From: Developer Services Planning [REDACTED]
Sent: 20 March 2024 10:20
To: Development Control <devcon@middevon.gov.uk>
Subject: RE: Consultation request - 24/00024/HOUSE Spring Cottage West Street Bampton

Location: Spring Cottage West Street Bampton Your ref: 24/00024/HOUSE Our ref: PC200324EX169NJ

Proposal: Erection of single storey rear extension

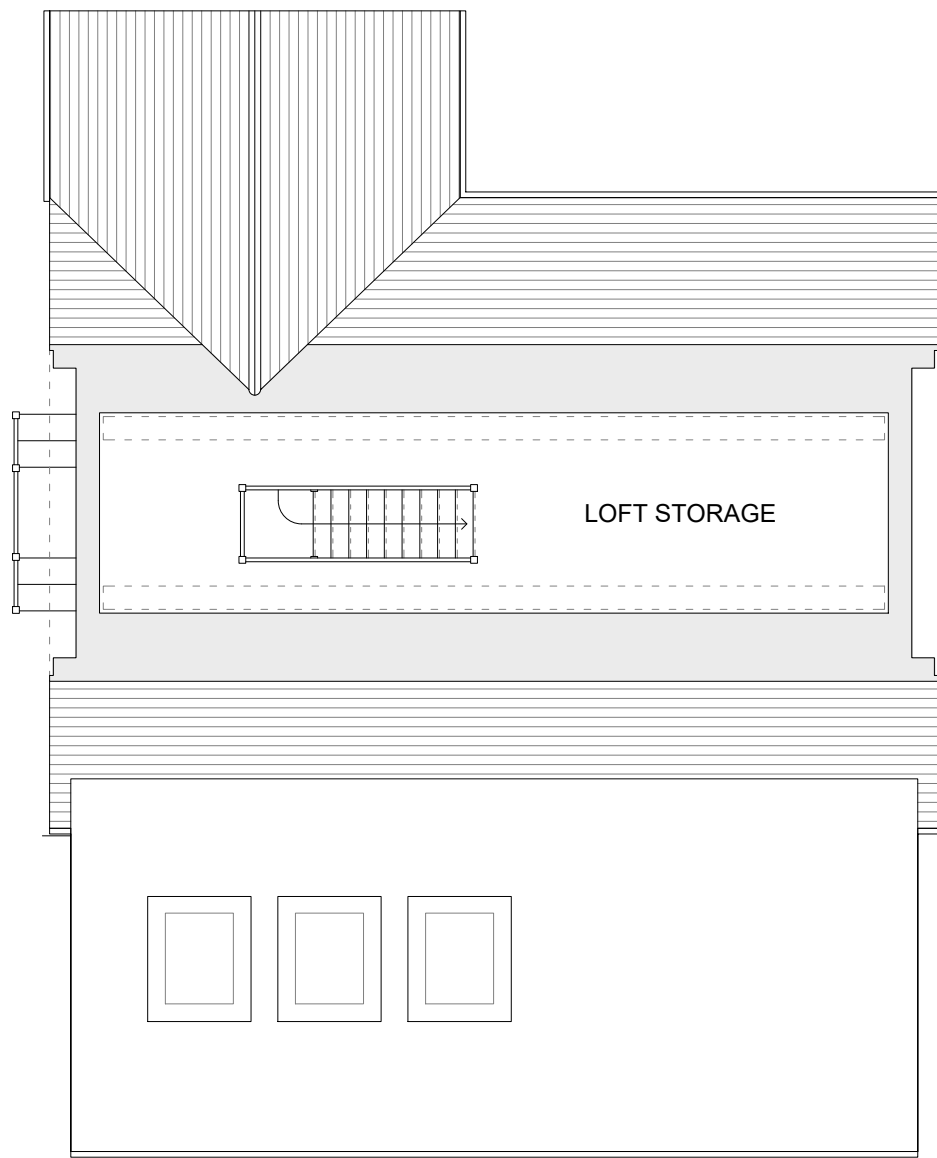
Please find attached a plan showing the approximate location of a public 150mm combined sewer in the vicinity. South West Water will need to know about any building work over or within 3 metres of a public sewer or lateral drain.

Having reviewed the applicant's current information as to proposed surface water disposal for its development (domestic roof and driveway run off only) Please note that discharging to the public combined sewerage network is not an acceptable proposed method of disposal, in the absence of clear evidence to demonstrate why the preferred methods listed within the Run-off Destination Hierarchy have been discounted by the applicant.

We will discuss with you whether your proposals will be affected by the presence of our apparatus and the best way of dealing with any issues as you will need permission from South West Water to proceed.

The applicant should demonstrate to your LPA that its prospective surface run-off will discharge as high up the hierarchy of drainage options as is reasonably practicable (with evidence that the Run-off Destination Hierarchy has been addressed, and reasoning as to why any preferred disposal route is not reasonably practicable):

1. Water re-use (smart water butts, rainwater harvesting, grey flushing toilets)
2. Discharge into the ground (infiltration); or where not reasonably practicable,
3. Discharge to a surface waterbody; or where not reasonably practicable,
4. Discharge to a surface water sewer, highway drain, or another drainage system; or where not reasonably practicable,
5. Discharge to a combined sewer. (Subject to Sewerage Undertaker carrying out capacity evaluation)
